Sent: 07 October 2013 20:51  
To: Planning  
Subject: Welwyn Hatfield Council Online Planning - Comment

Application Number: N6/2013/1938/MA

Address: 13 Dellcott Close, Welwyn Garden City, Herts. AL8 7BB Comment Type: Object

Title Proposed Materials

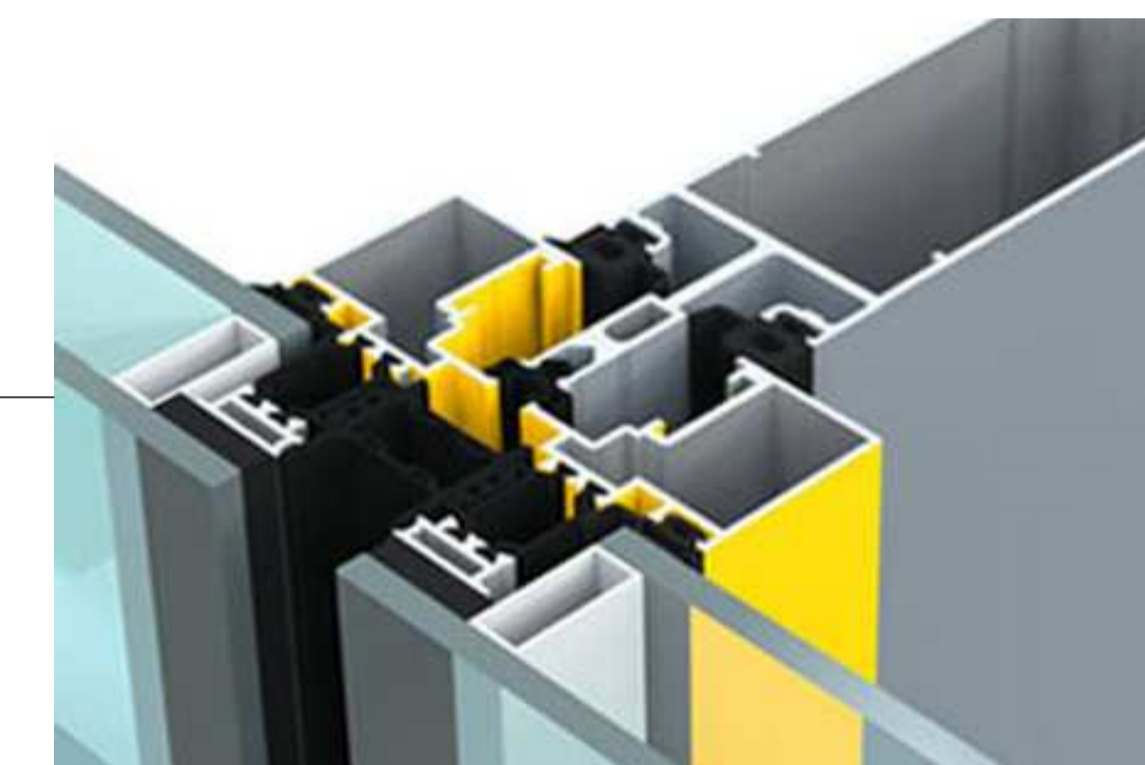
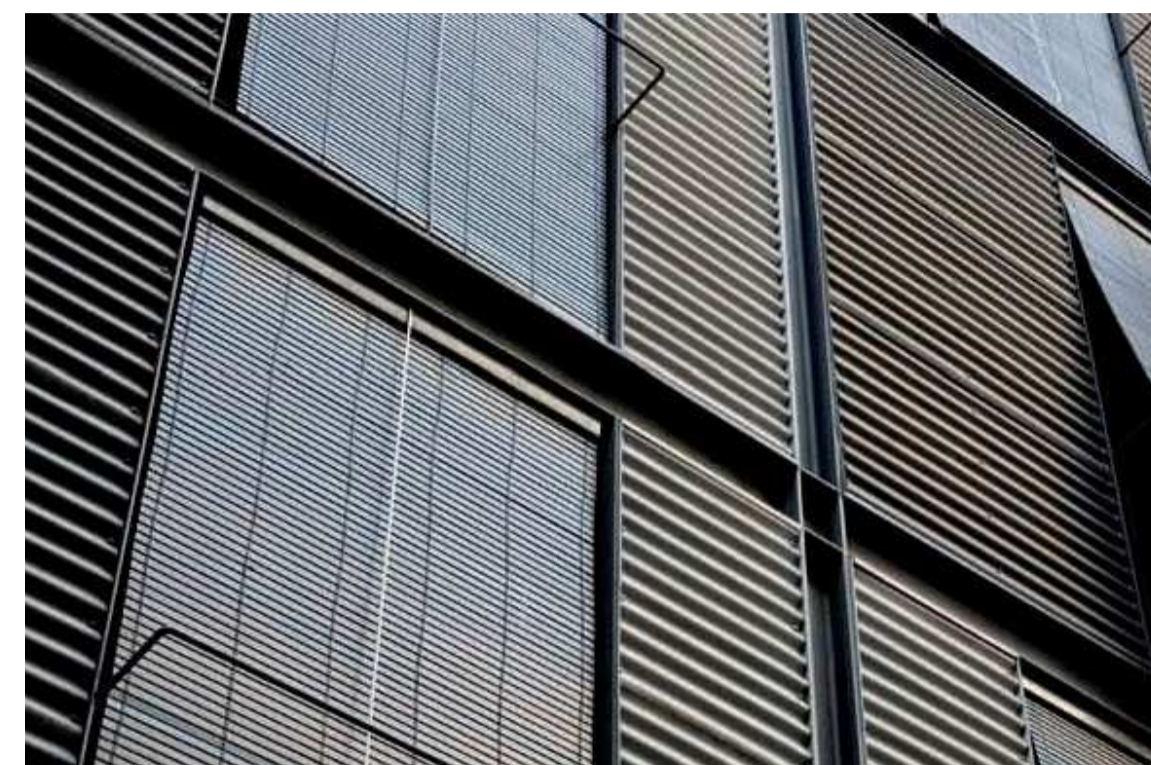
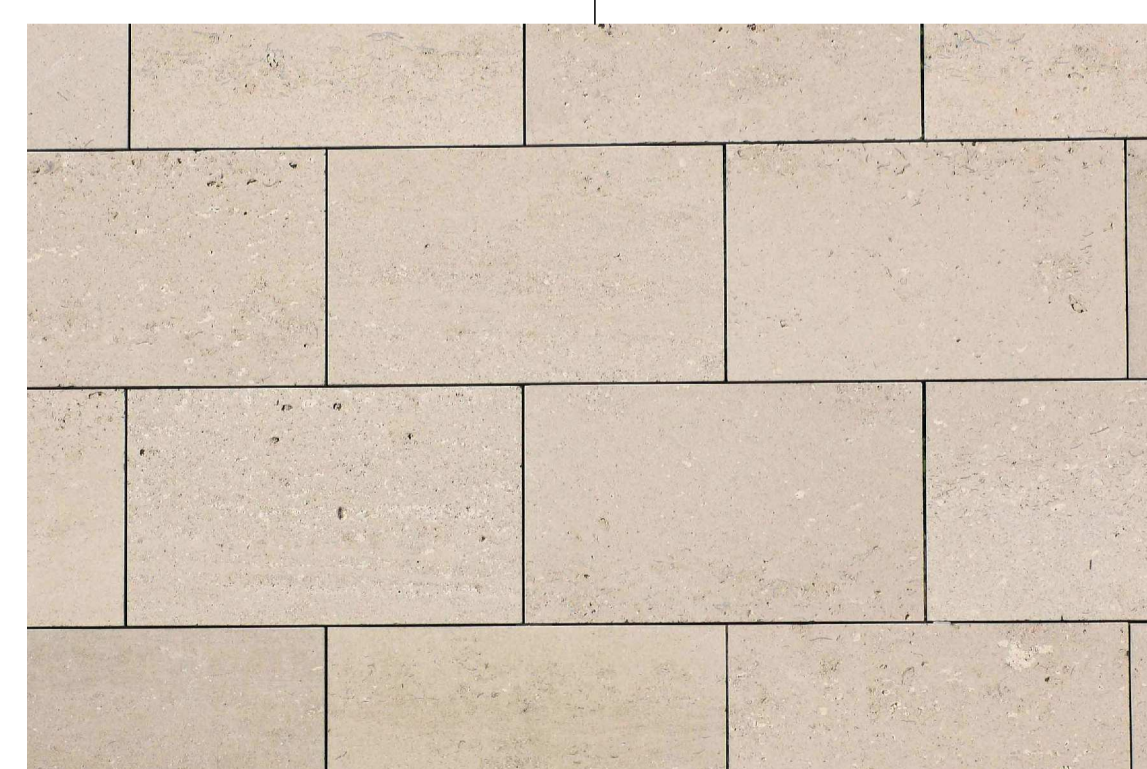
I do not object to the principle of extending the Council Offices, however I am concerned about the glazed elevation which in my opinion dominates the rear elevation of the Council Offices in a manner alien to the neo georgian design of the building and its surroundings. The proposed extension is too high, too wide and the proscenium arch is clumsy. The Council's planning consultants mistakenly claim it will not be seen. However it is an important elevation seen together with the McCarthy and Stone development which I personally consider to be a handsome addition to the locality.

Placing such a major feature which forms the civic entrance onto the rear of the building effectively spins the building so it faces onto an unpleasant car park and the flank wall of the Waitrose supermarket. This area will be dominated by a curtain wall of glass. This scheme misses the opportunity to enhance this area, producing an attractive landscaped link for pedestrians and cyclists. The applicants could work harder at this. Otherwise, the scheme will fail to create a safe and accessible environment.

There is no lighting plan for the scheme. I am concerned that the glazed frontage to the extension if not controlled could emphasise the poor design with significant glare. The application should be refused in accordance with the National Planning Policy Framework which states; "permission should be refused for development of poor design that fails to take the opportunities available for improving the character and quality of an area and the way it functions" (para 64).
